Application Ref:	3/2026/0322			 Ribble Valley Borough Council www.ribblevalley.gov.uk
Date Inspected:	22/7/25	Site Notice:	19/5/26	
Officer:	BT			
DELEGATED ITEM FILE REPORT:				APPROVAL

Development Description:	Reserved Matters Application for appearance, landscaping, layout and scale for the erection of a farm worker's dwelling (self-build).
Site Address/Location:	Land at Lower Standen Hey Farm, Whalley Road, Pendleton, BB7 1PP.

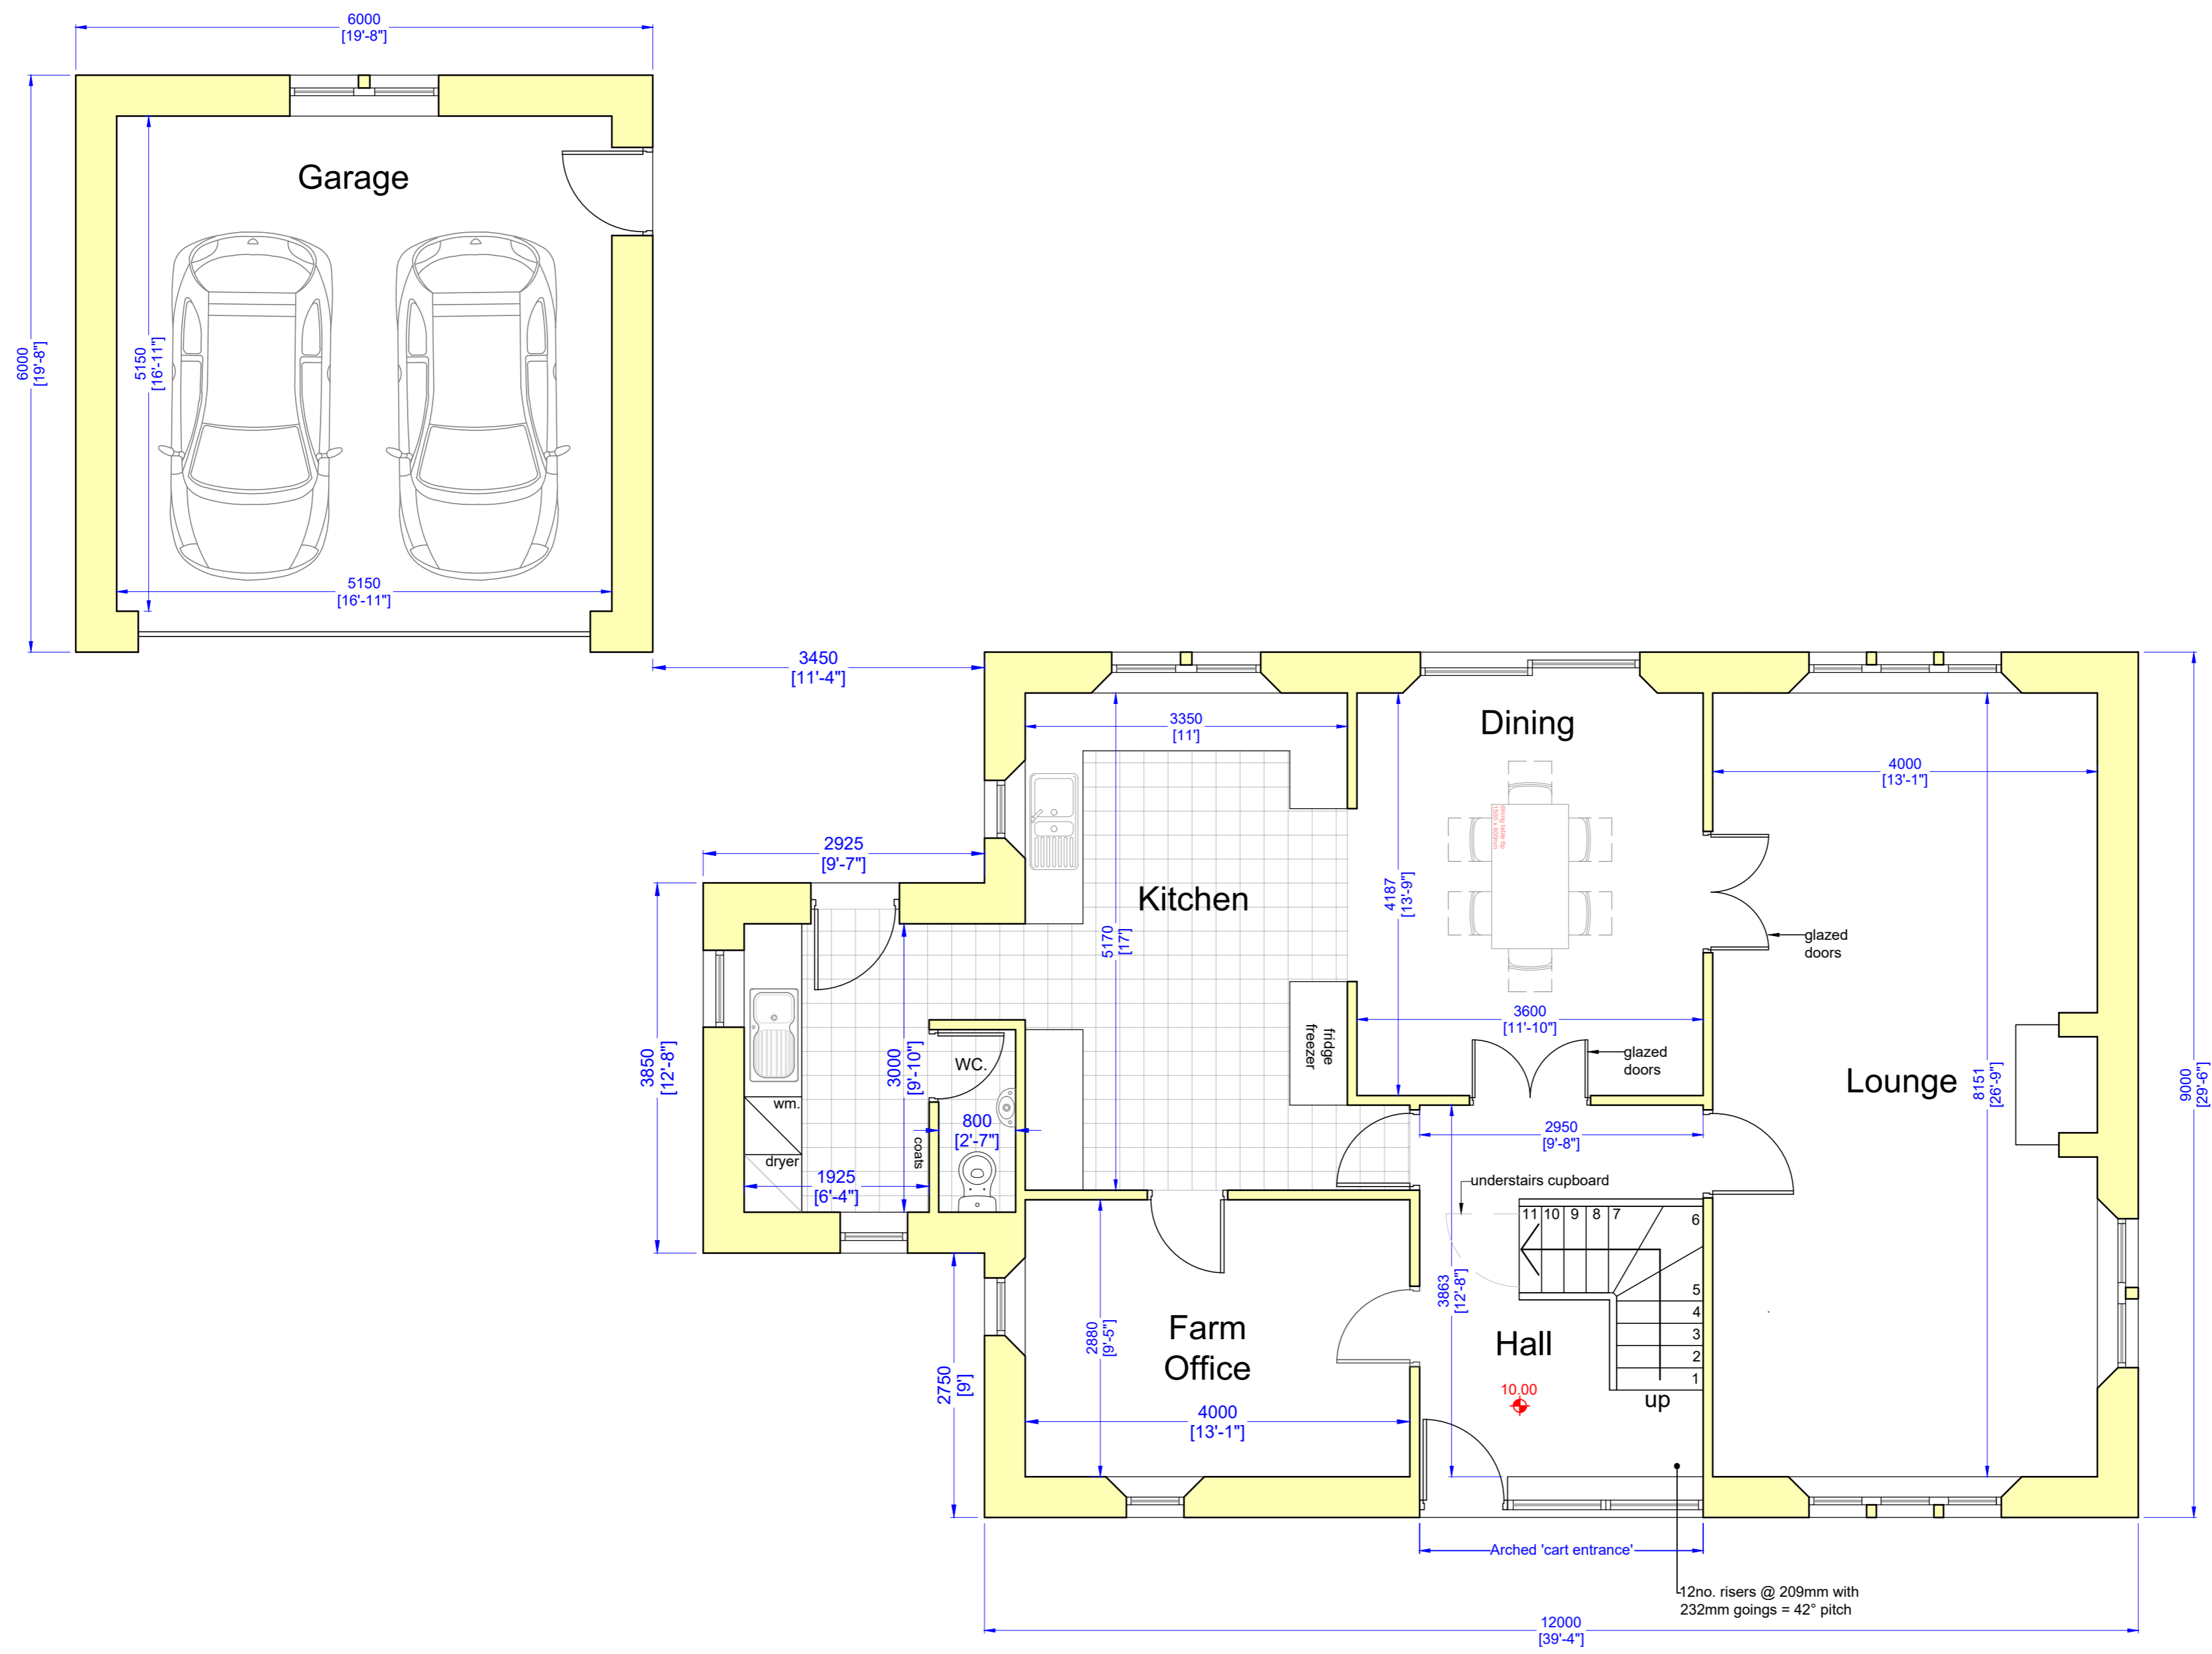
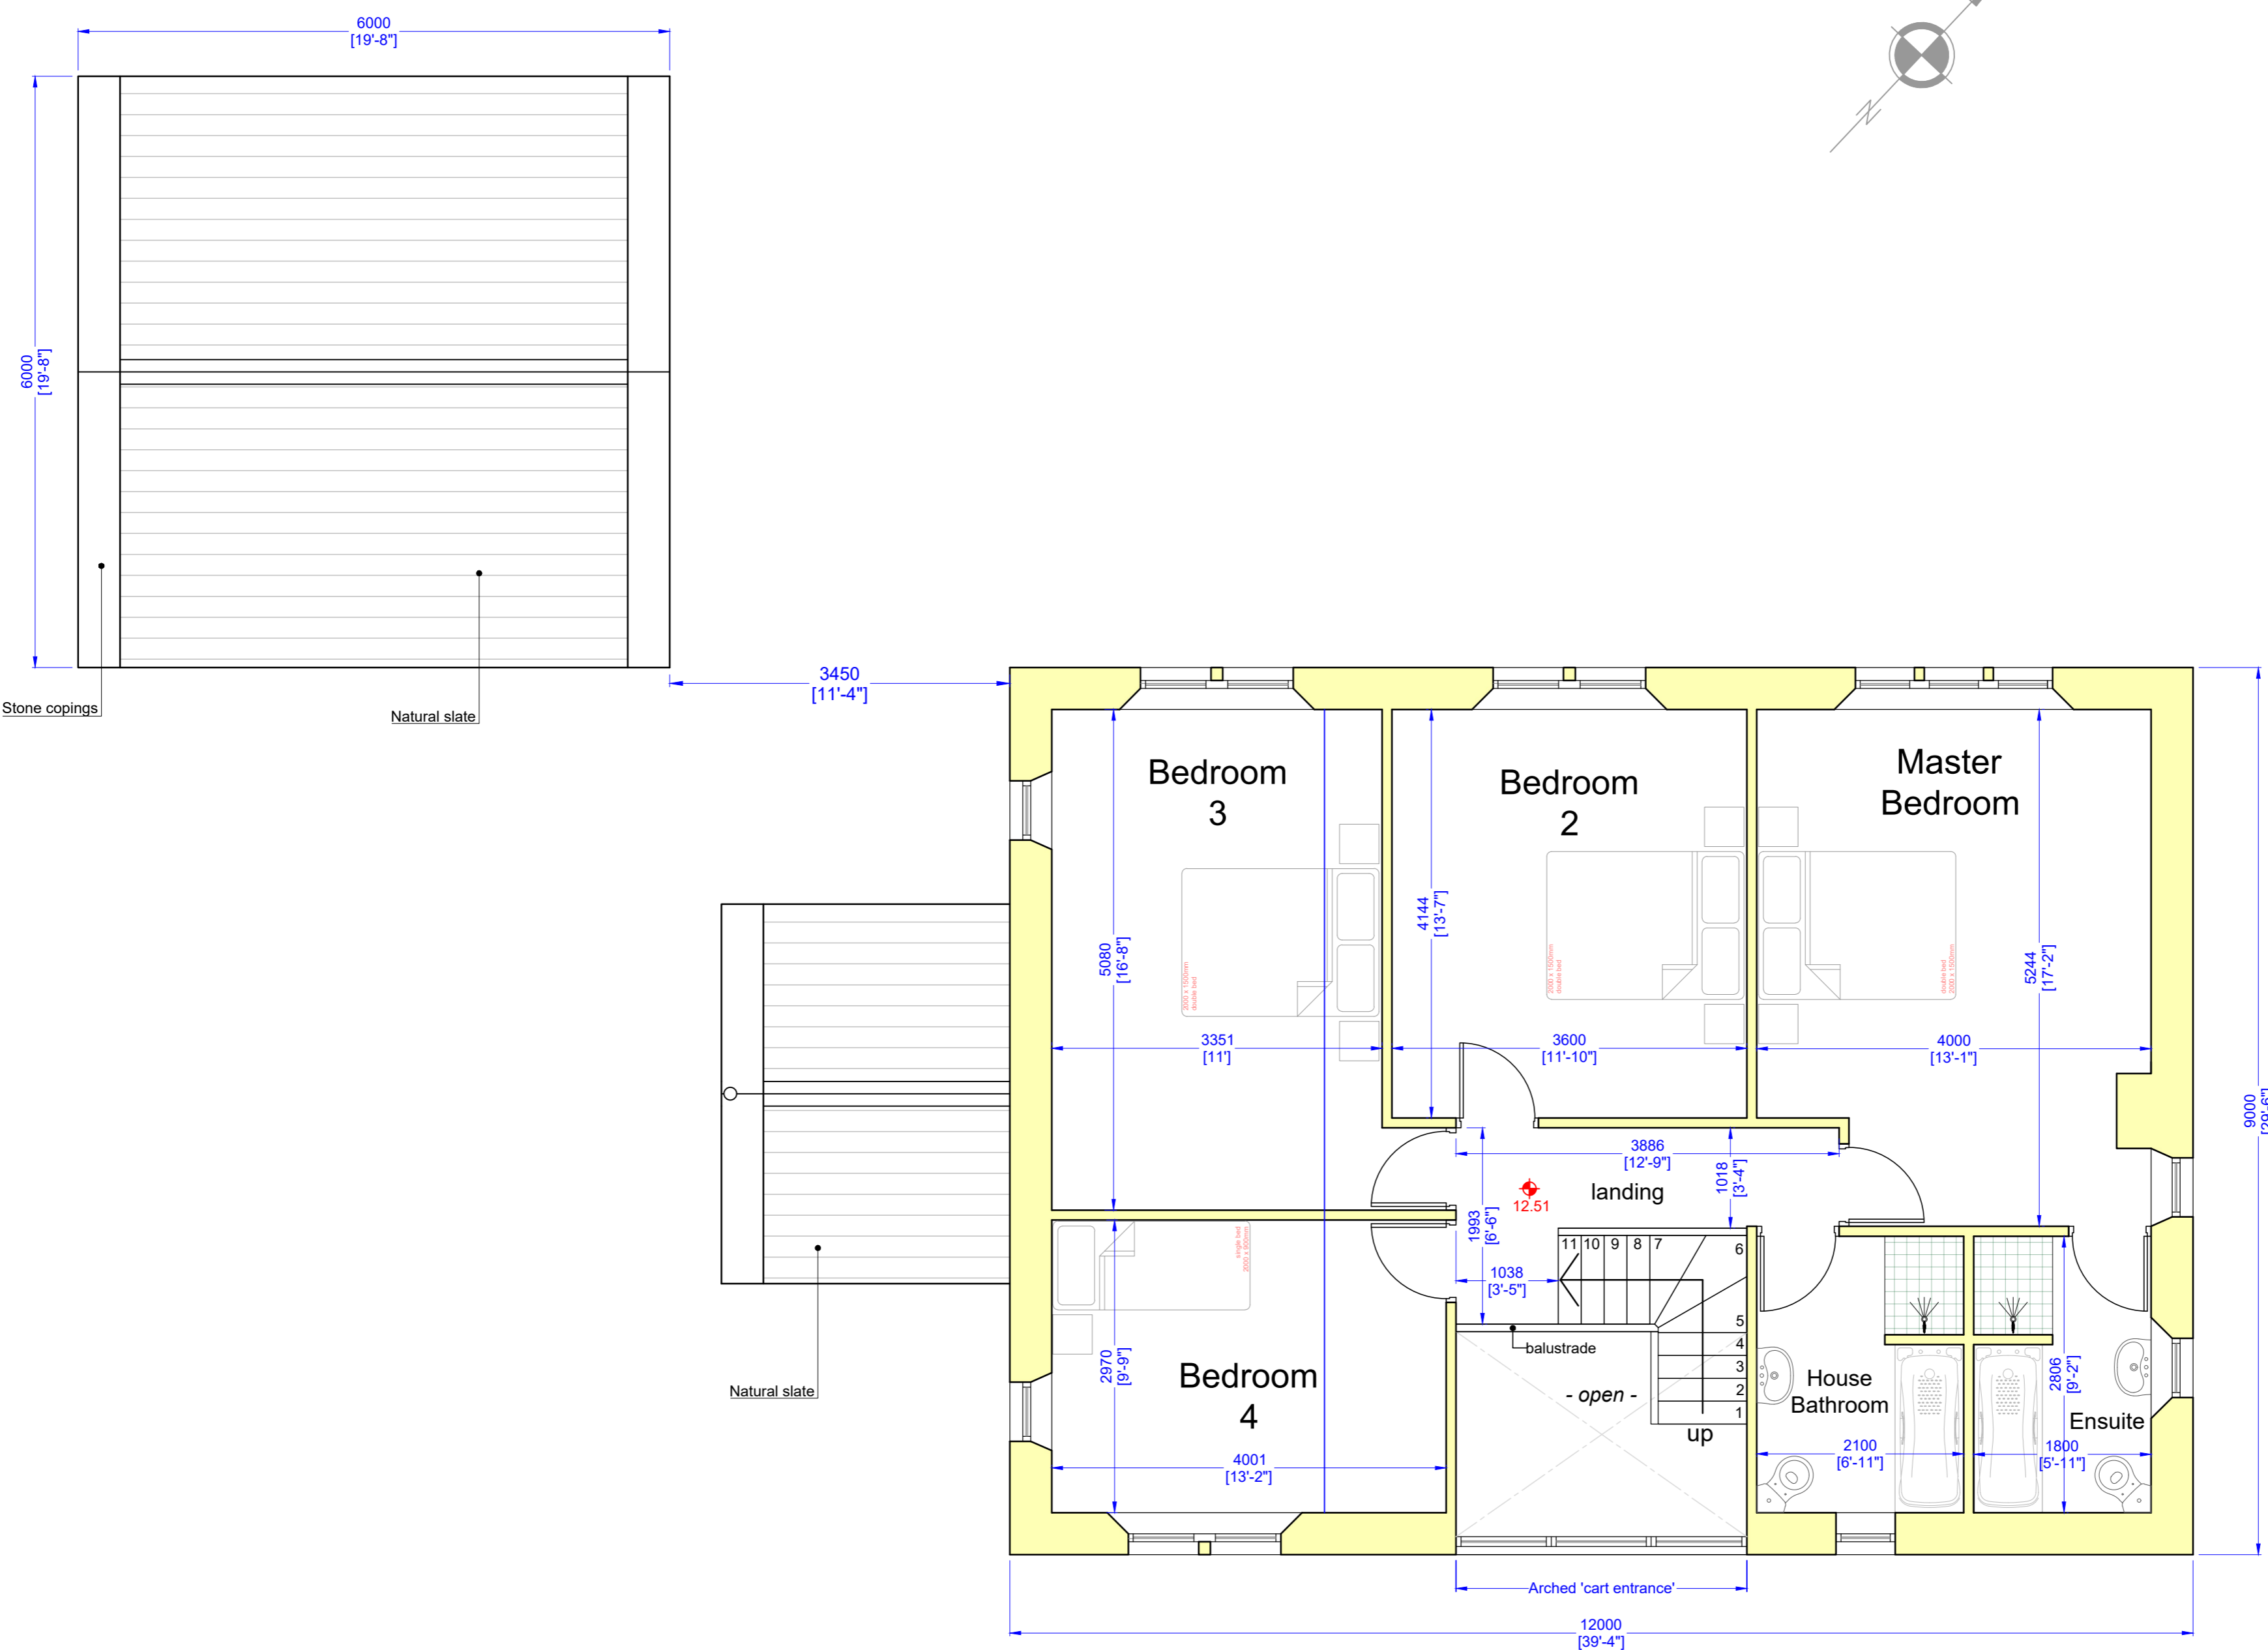
loss of privacy, natural light or outlook. In addition, the submitted proposed plans show that all habitable rooms within the proposed dwelling would be served by a sufficient quantity of window openings therefore future occupants of the dwelling would receive adequate levels of natural light and outlook.
